November 6, 2017
File: 173cl

RE: Nathan Clifford, 180 Falmouth Street

NATHAN CLIFFORD RESIDENCES
STAIRWELL WALL REPAIR

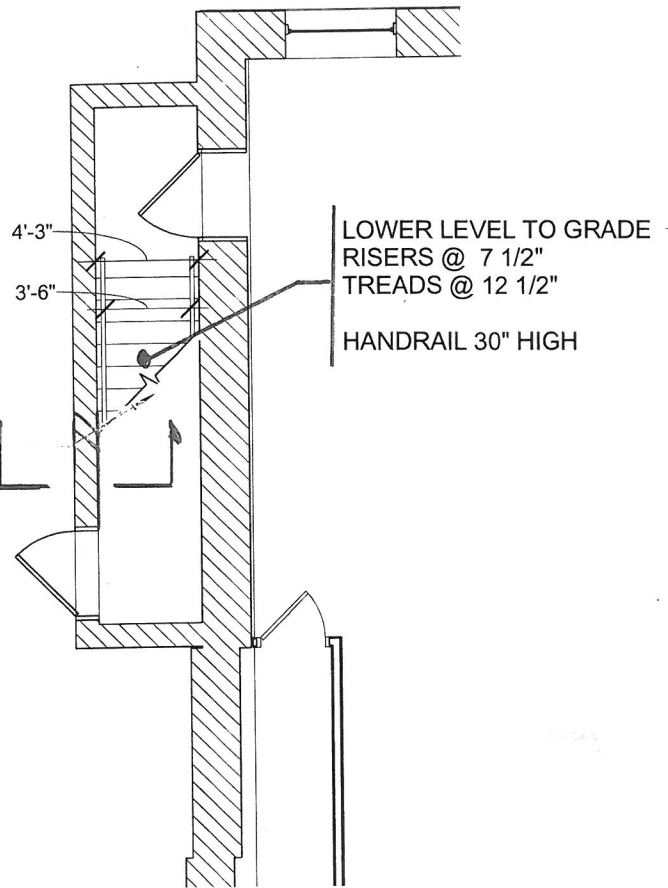
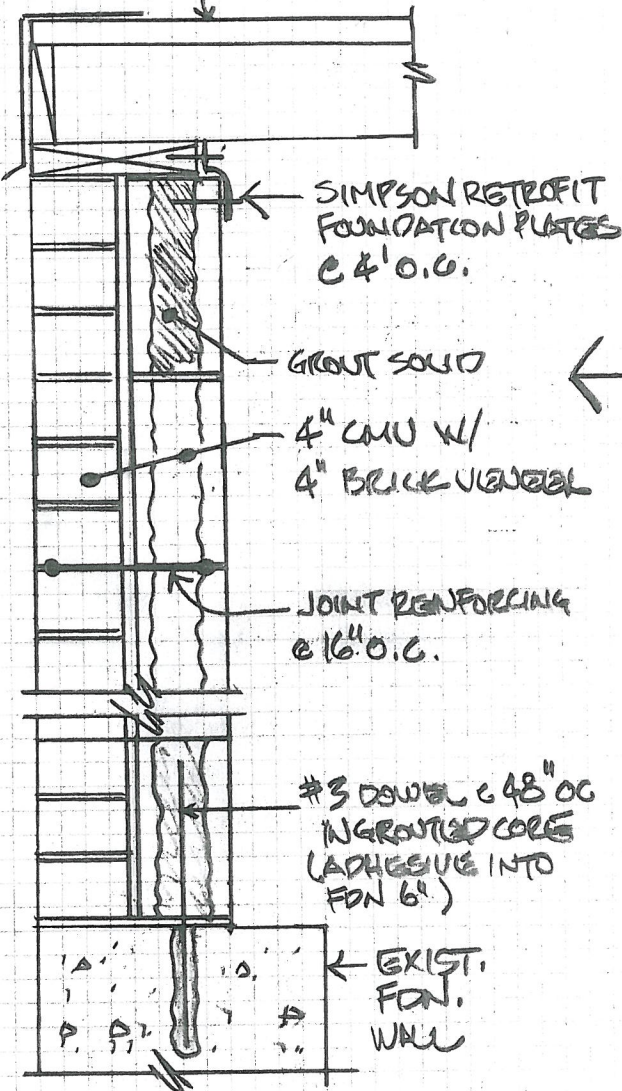
Today we met at the site of the Nathan Clifford Residences. A vehicle crashed into the side of the covered stairwell on the Payson Street side of the building. The stairwell leads into the basement, and there is a one-story flat roof over the stairwell. The one-story wood-framed roof structure is supported by a concrete foundation wall with a wall system of 4" concrete block (CMU) and 4" yellow brick. The wall is pushed into the stairwell at roughly the mid-point of the wall, with the wood top plate slid away from the roof system.

We visually examined the walls and foundation. There does not appear to be any damage to the foundation wall or main building wall, or one-story roof. The impact from the vehicle sheared off the connection between the top of the wall and the underside of the roof framing, damaging a portion of the CMU/brick wall and top plate but leaving the remainder of the area undamaged. Basically, the marginal connection between the wood top plate and the masonry wall acted like a fuse. The vehicular impact force on the wall was taken by the one-story wall and not transmitted to the main building due to the release of the top plate connection.

We understand the damaged section of wall will be replaced "in kind" and we agree with this repair approach.
